15 October 2012

CR2012/008999
SF2012/001339
MJ

WANGI ROAD (MR217): EXHIBITION OF ENVIRONMENTAL ASSESSMENT FOR AWABA WASTE MANAGEMENT FACILITY – WILTON ROAD, TORONTO (MP 10_0139)

Figure 5 Upgraded Intersection Form of Wilton Road/Wangi Road

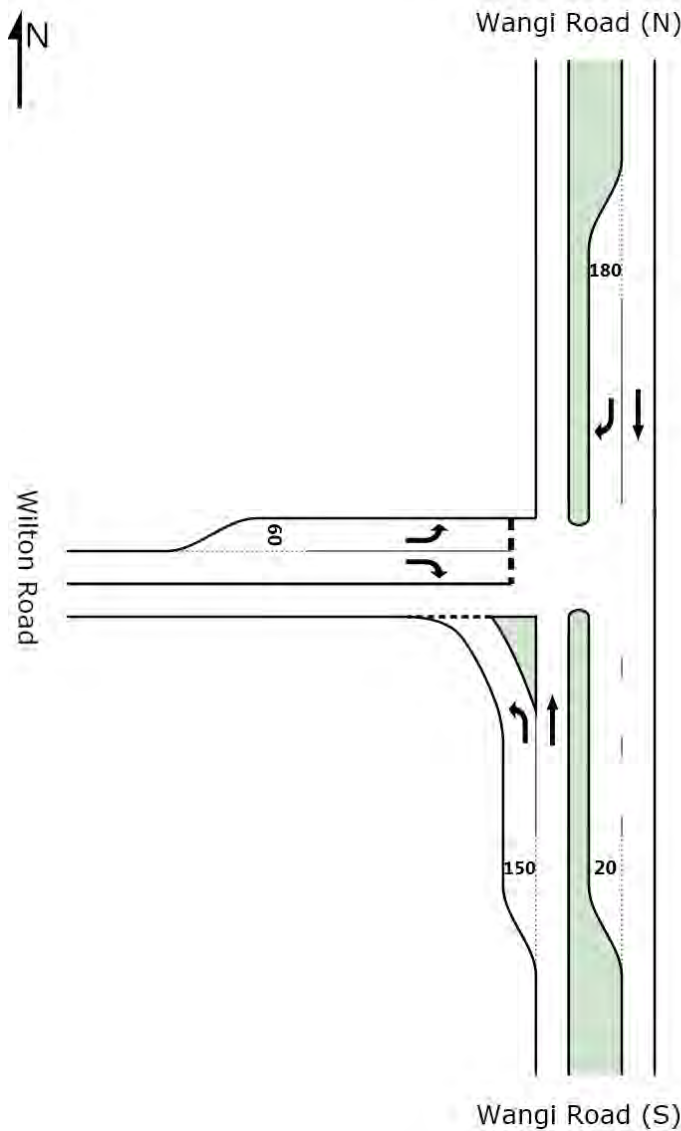
RMS has noted that Lake Macquarie City Council will ensure that the intersection of Wangi Road (MR217) and Wilton Road is upgraded to improve conditions for vehicular traffic and to reduce average delays experienced at the intersection for vehicles turning right onto Wangi Road.
